July 11, 2024

Planning and Community Development
El Paso County, Colorado
Attention: Kari Parsons
2880 International Circle, Suite 110
Colorado Springs, CO 80910

Re: Letter of Intent for the Proposed Monument Ridge Metropolitan District Nos. 1-4

## Special Districts and Zoning Boundary Overlay

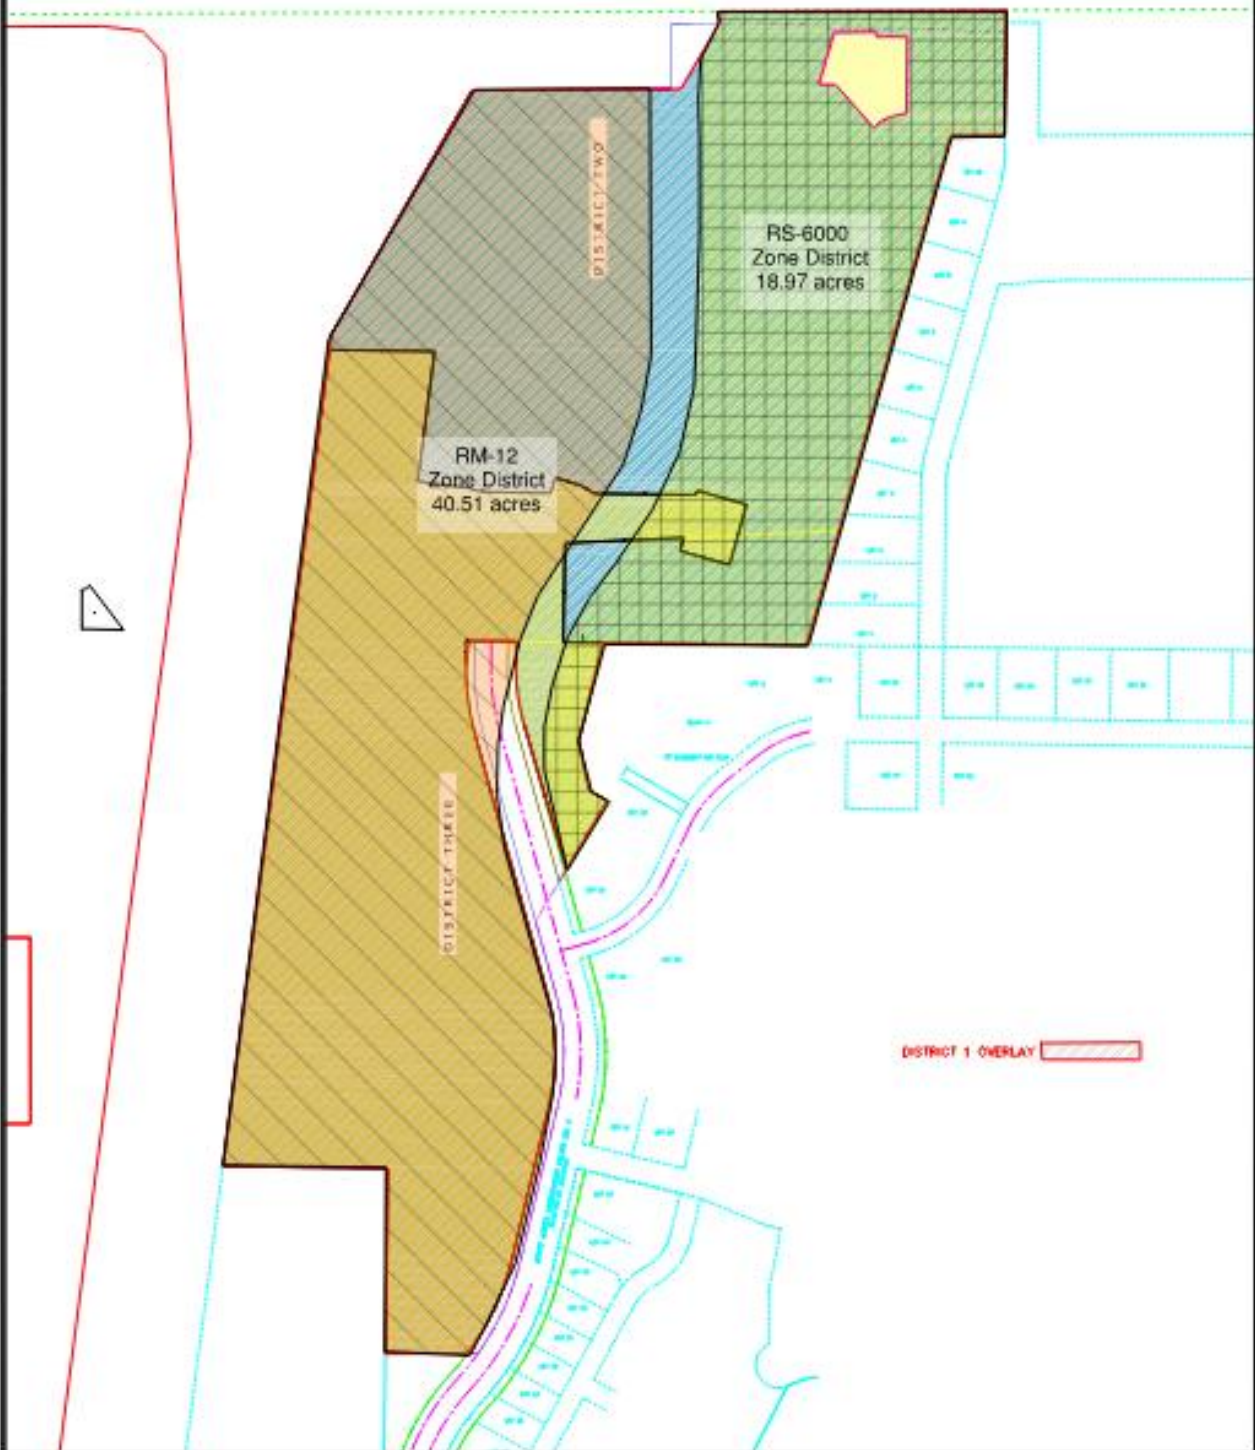
Looks like District 1 is solely a Wetlands area.

Staff is reading this to be a placeholder District 4 to eventually include land located west of I25 and no applications have been submitted at this time- is that correct? D4 is not generating revenue in Financial Plan provided. How is there a need now for District 4?

Provide evidence that
Misty Acres cant
provide services via a
letter related to a
portion of D3 and or
is excluding the land
in D3; staff doesnt
see the need for D4
as it serves no areas
within the proposed
Districts
Boundary...and the
D4 is not supported in
the Financial Plan.
Misty Acres Service
Plan indicate that the
parcel proposed to be
in D3 is currently
intended to provide
revenue for
commercial property
as identified in the
Misty Acres service
Plan.
